RE: PD-17-00001 Marian Meadows Planned Unit Development

Thank you for the opportunity to comment on the Marian Meadows Planned Unit Development Agreement (DA-19-00001). Washington Department of Fish and Wildlife (WDFW) previously commented on the PUD application and we appreciate that elements of those comments were incorporated into the final decision and conditions to address fish and wildlife habitat concerns. WDFW remains concerned over details to adequately address the stream typing and future ability for landowners to subdivide the large parcels to the east of the PUD.

Critical Areas

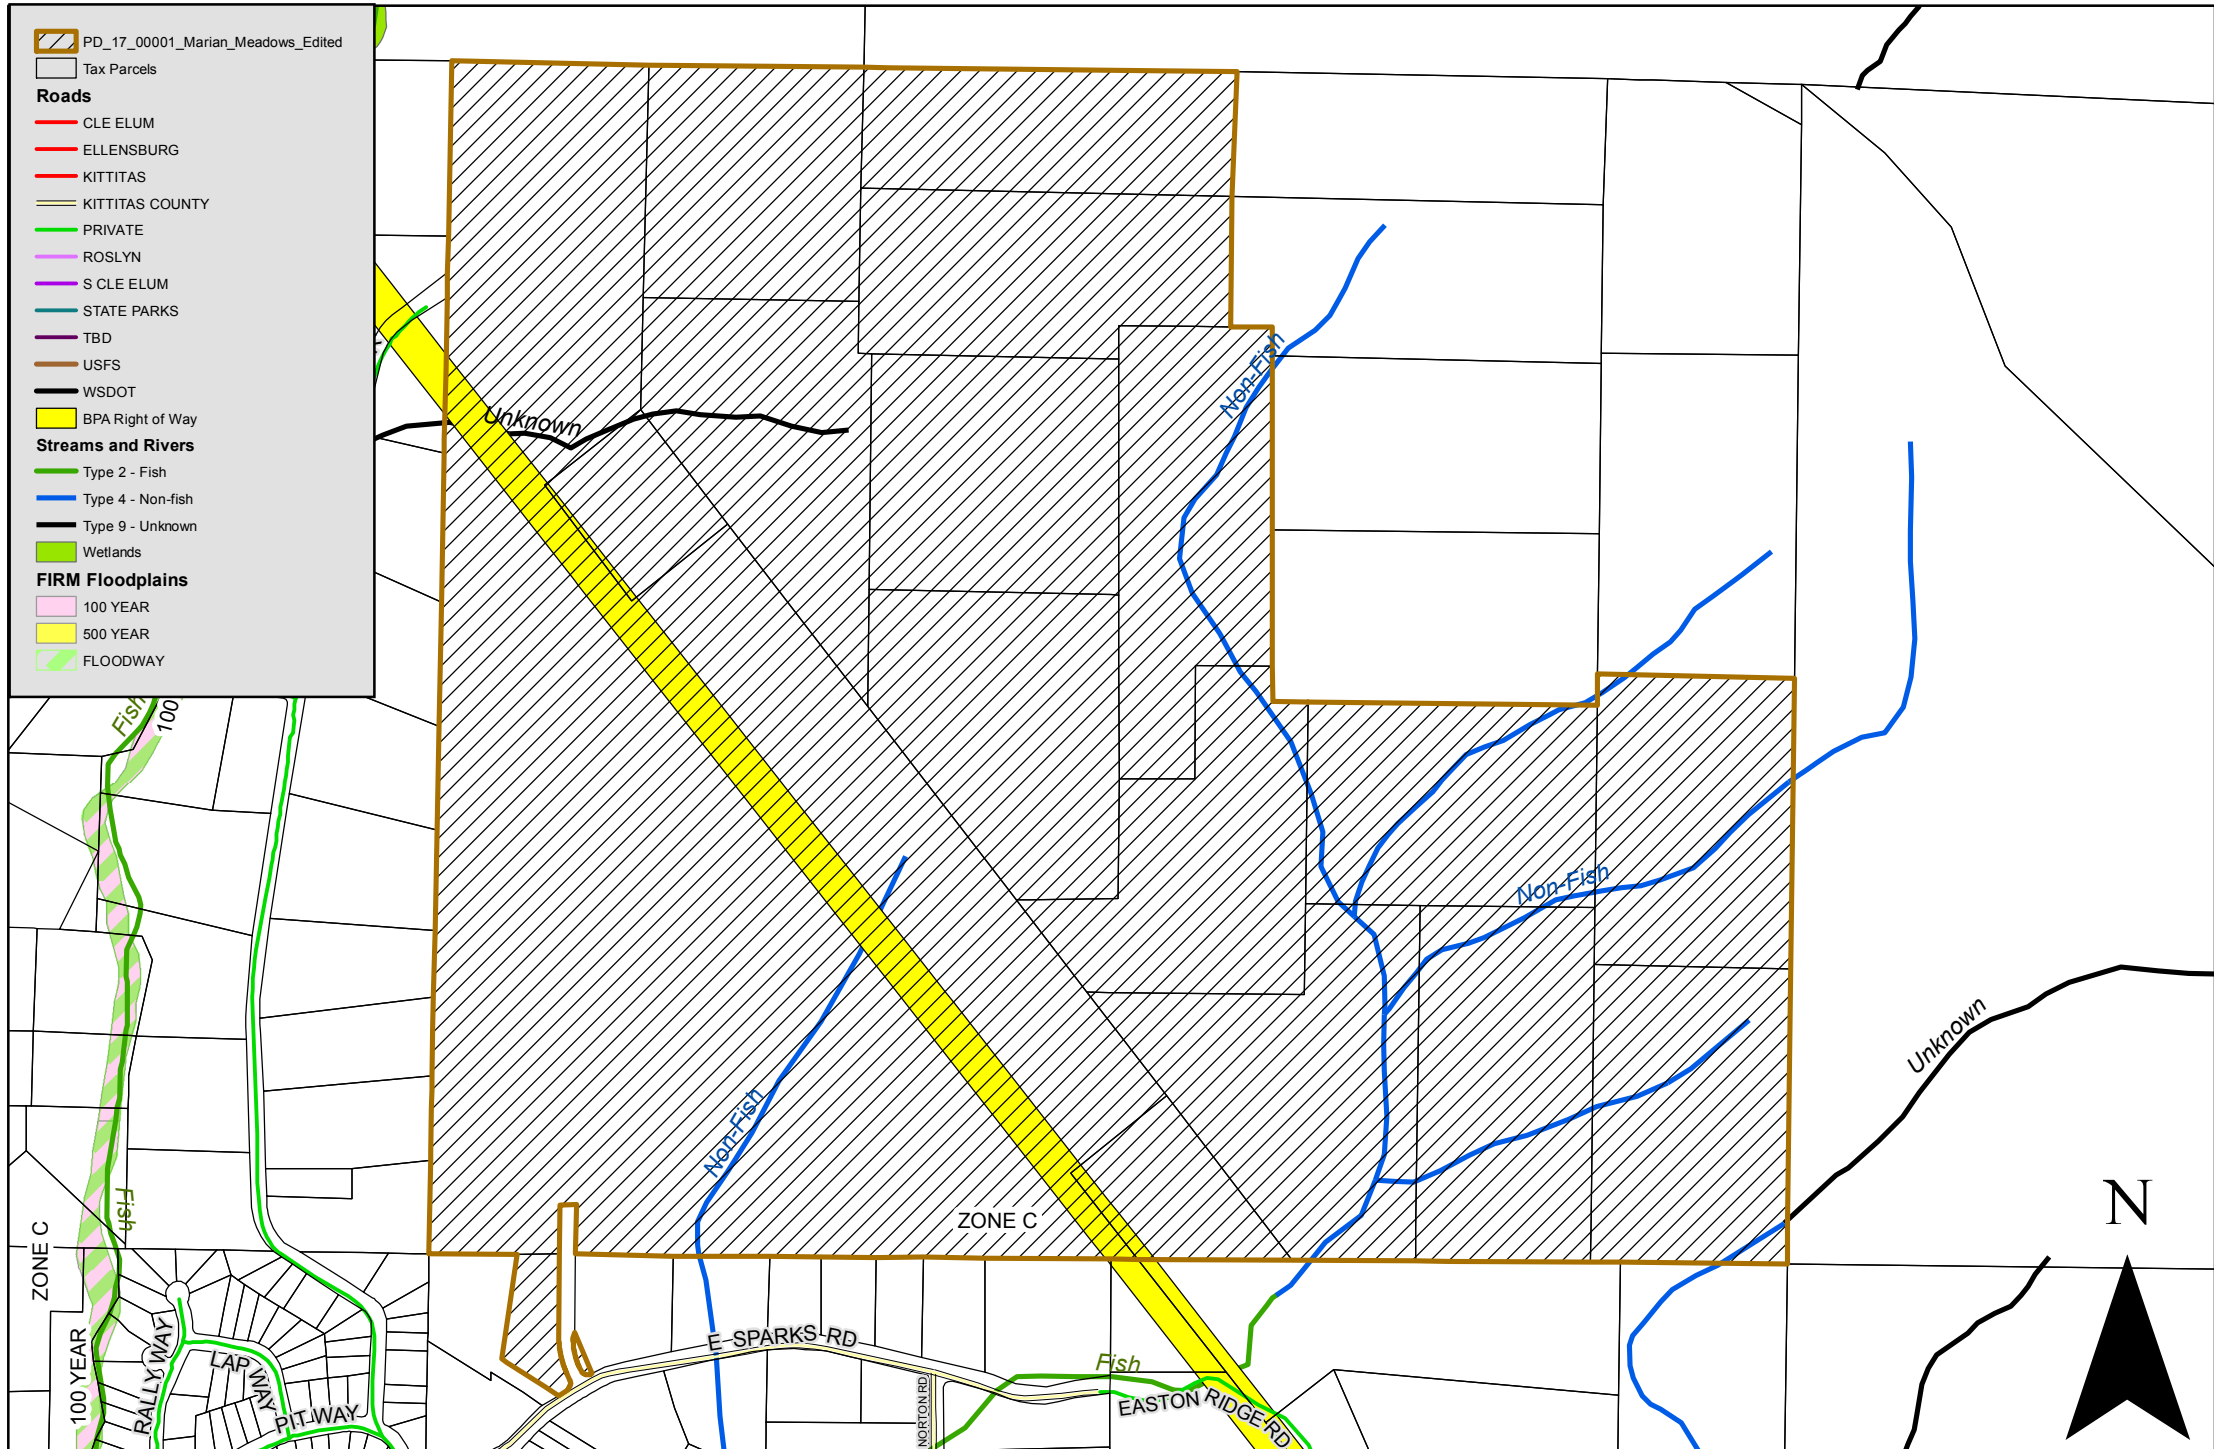
WDFW appreciates that the applicant looked at the mapped stream and provided a written assessment that it did not qualify as a typed stream. However, the information provided by Raedeke Associates, Inc. only provided a written description on the site with no pictures. It is difficult for WDFW to concur with this assessment without photos and only a written assessment. Further, as shown on the attachment, WDFW believes the typed stream is likely in the wrong location as evidenced by the discrepancy in LiDar.

WDFW requests that the applicant provide photo documentation of the stream or ability for WDFW to do an onsite concurrence of the stream assessment. WDFW also requests that the applicant use the location of the actual drainage location, as evidenced by the LiDar, rather than the potentially inaccurate mapped stream location.
